**United Utilities Water Limited  
Developer Services & Planning**  
Warrington North WWTW  
Barnard Street off Old Liverpool Road  
Gatewarth Industrial Estate  
Sankey Bridges  
Warrington  
WA5 1DS

**Your ref:** 3/2016/1128  
**Our ref:** DC/16/5112  
**Date:** 20-DEC-16

**Location:** Former LCC Depot Land off Dixon Rd, Longridge  
**Proposal:** construction of 6 dwellings

GA3057-PSP Rev-C

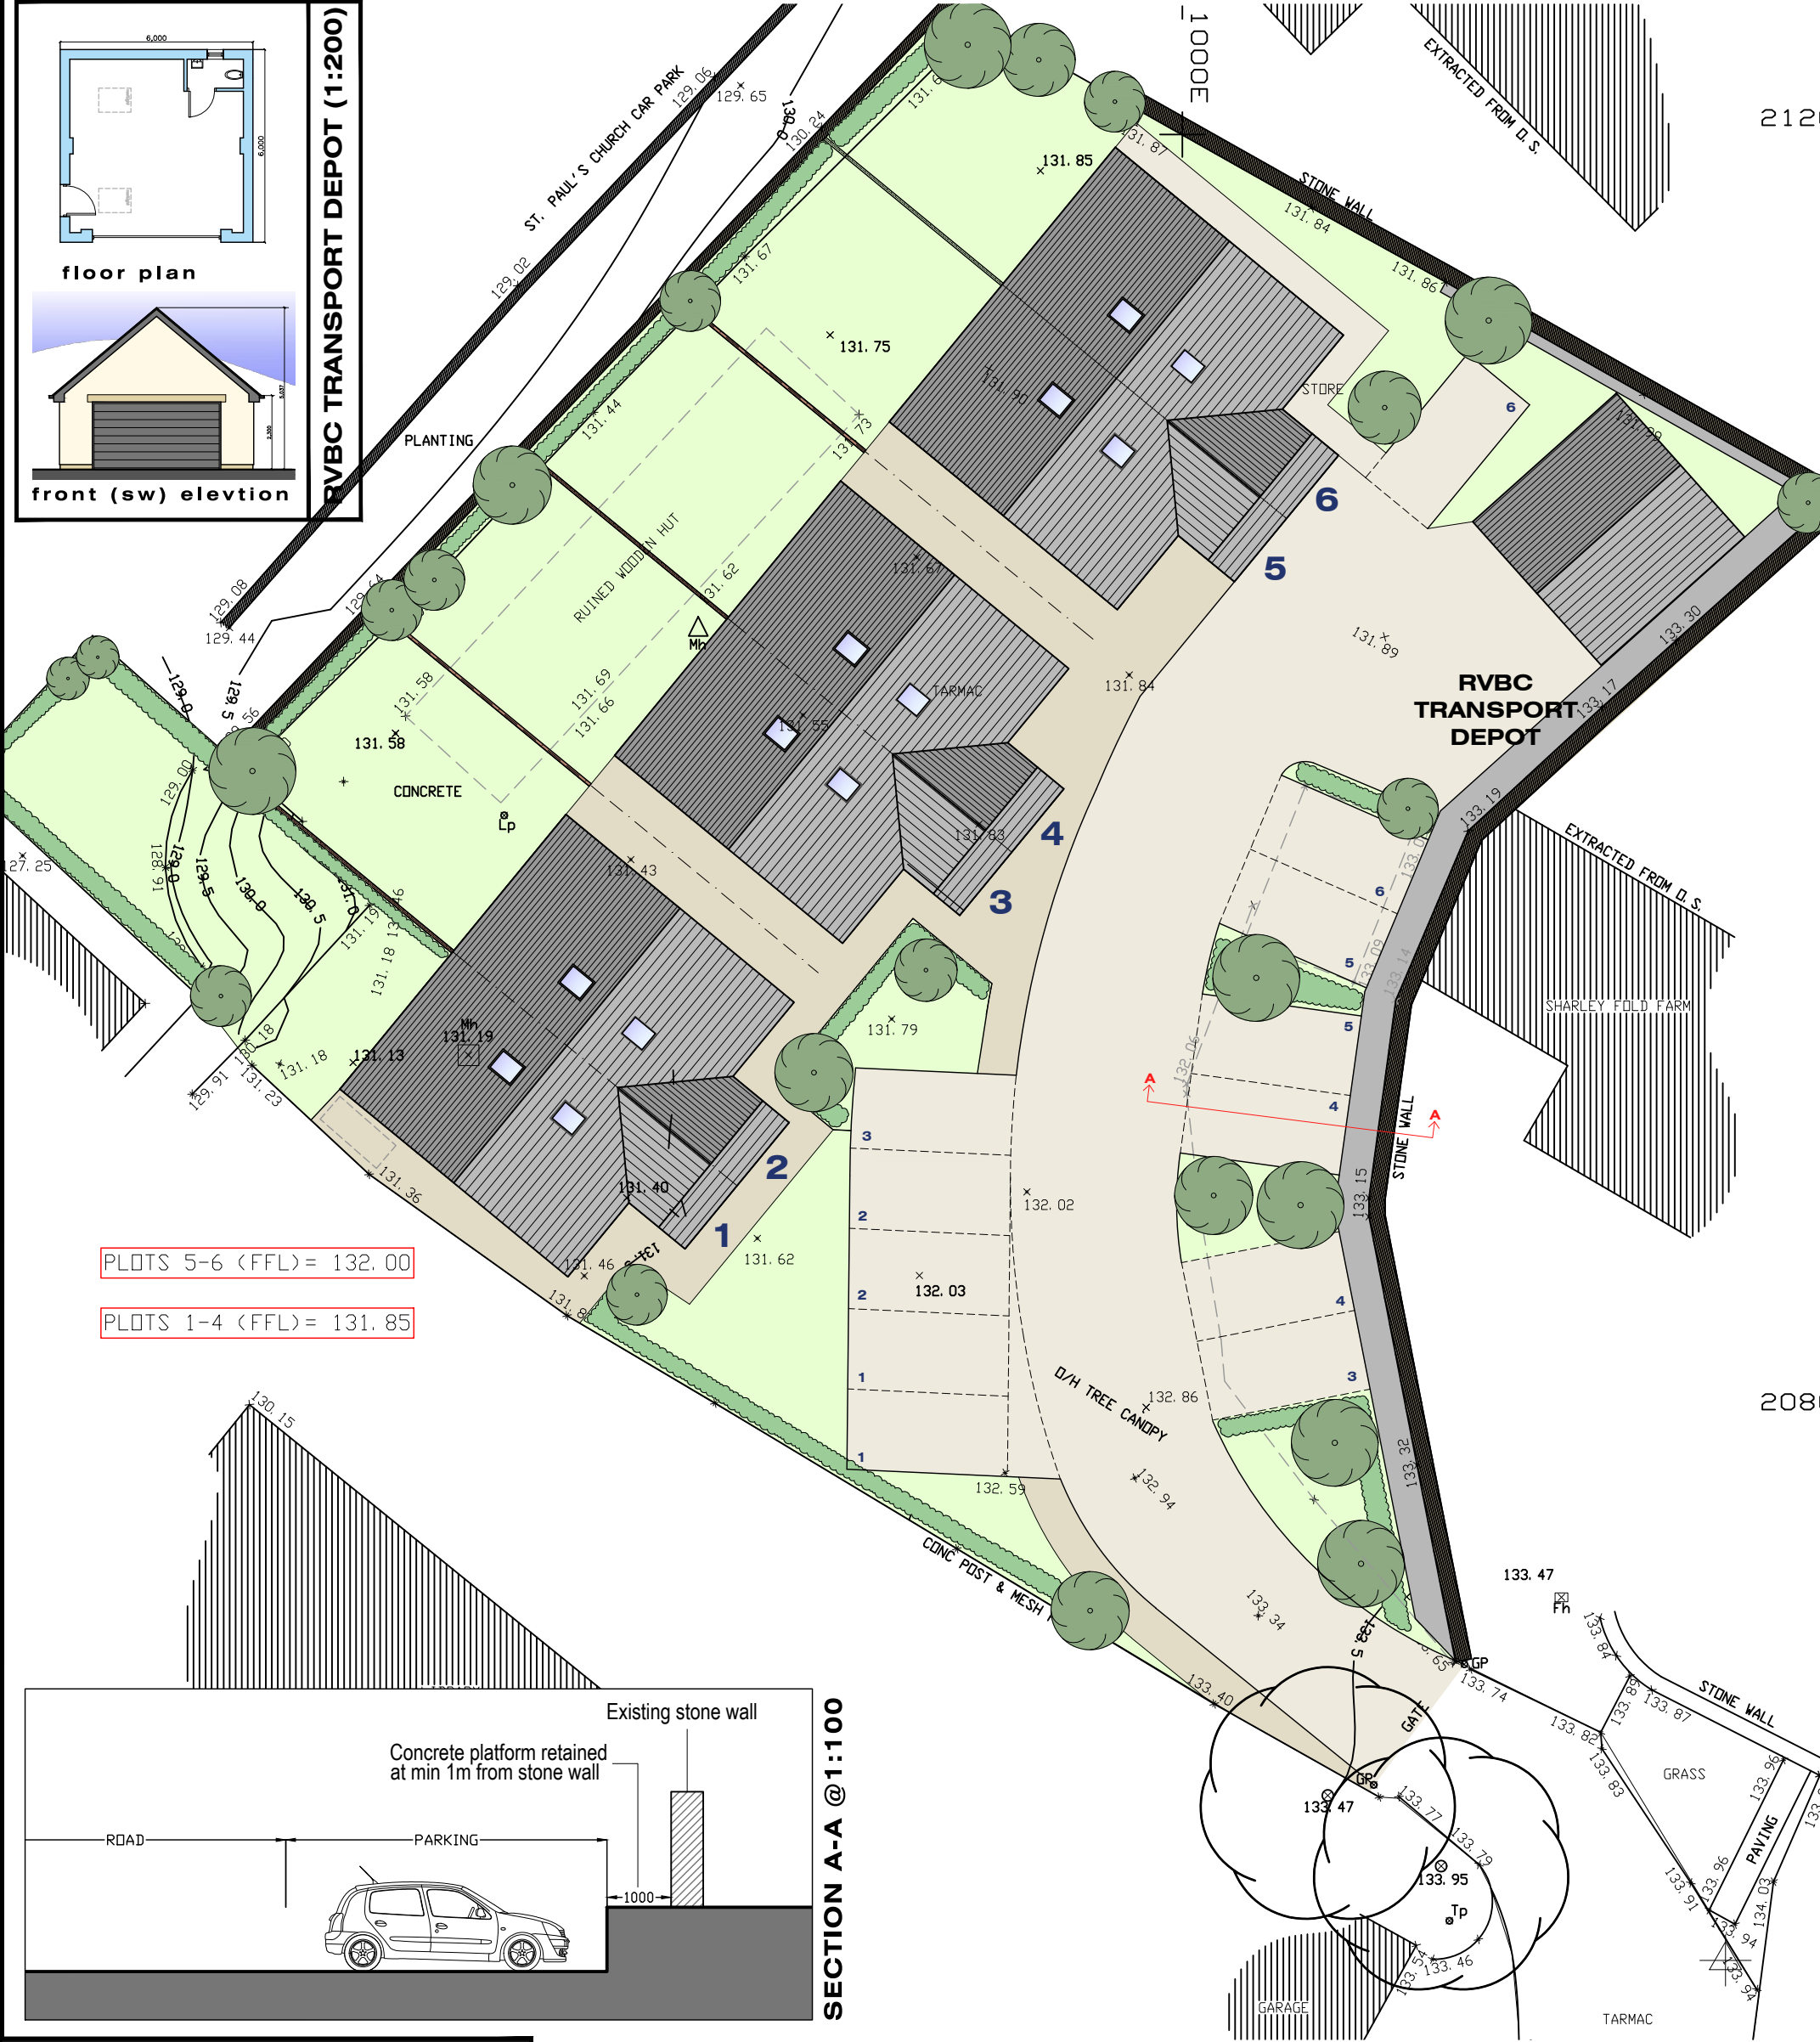
A public sewer crosses this site and we will not grant permission to build over or within 3 metres of the centre line of it. The requirement for our permission is detailed within the guidance that supports Part H4 of the Building Regulations. If the proposals do not meet these specifications a modification of the site layout or a diversion of the public sewer at the applicant's expense, may be necessary. To establish if a sewer diversion is feasible, the applicant must discuss this at an early stage with our Developer Engineer at [wastewaterdeveloperservices@uuplc.co.uk](mailto:wastewaterdeveloperservices@uuplc.co.uk) as a lengthy lead in period may be required if a sewer diversion proves to be acceptable.

Deep rooted shrubs and trees shall not be planted within the canopy width (at mature height) of the public sewer and overflow systems. Trees should not be planted directly over sewers or where excavation onto the sewer would require removal of the tree.

**A water main crosses the site. As we need access for operating and maintaining it, we will not permit development in close proximity to the main. You will need an access strip of no less than 5 metres, measuring at least 2.5 metres either side of the centre line of the pipe. The applicant must comply with our standard conditions, a copy of which is enclosed, for work carried out on, or when crossing aqueducts and easements. This should be taken into account in the final site layout, or a diversion will be necessary, which will be at the applicant's expense. Any necessary disconnection or diversion required as a result of any development will be carried out at the developer's expense. Under the Water Industry Act 1991, Sections 158 & 159, we have the right to inspect, maintain, adjust, repair or alter our mains. This includes carrying out any works incidental to any of those purposes. Service pipes are not our property and we have no record of them.**

The level of cover to the water mains and sewers must not be compromised either during or after construction.
